**From:** Liz Rogers [REDACTED]  
**Sent:** 25 September 2017 09:42  
**To:** Planning.Responses  
**Subject:** RE: Planning Consultation on: A/169/17/OUT

**App No:** A/169/17/OUT

**Address:** Land west of Brook Lane & South of A259 Angmering

**Proposal:** Outline application with all matters reserved for demolition of existing buildings on site & erection of a mixed use development comprising up to 90 No. residential units, a care home (Use Class C2 & C3) & ancillary facilities including railway crossing, together with associated access, car parking & landscaping (resubmission following A/44/17/OUT).

Figure 4: Yellow areas receptor site and holding area

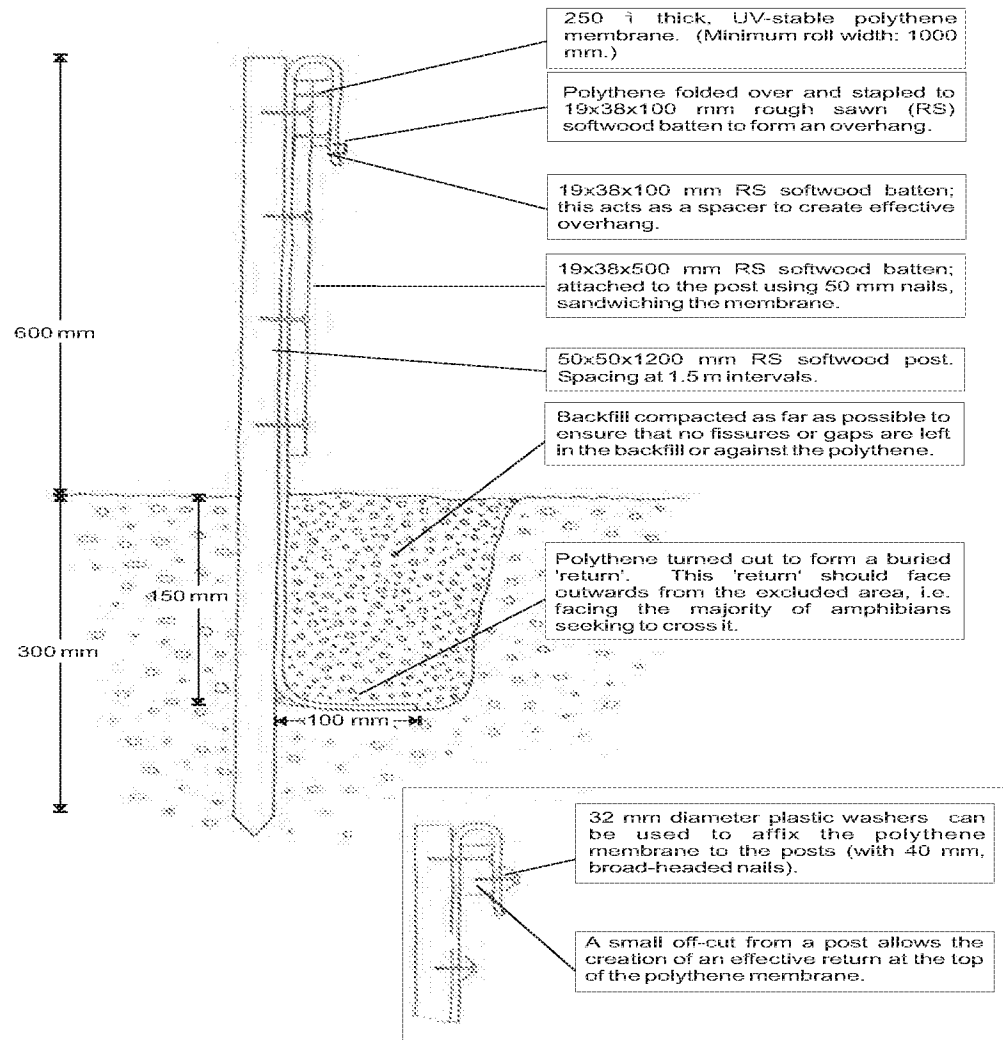
The reptile survey has shown that there is a small population of reptiles onsite. Due to this mitigation has been proposed within the Reptile Survey 2017 and we are happy that the proposed mitigation is suitable and this can be conditioned. The applicant should note that no works can commence until the reptile translocation has taken place.
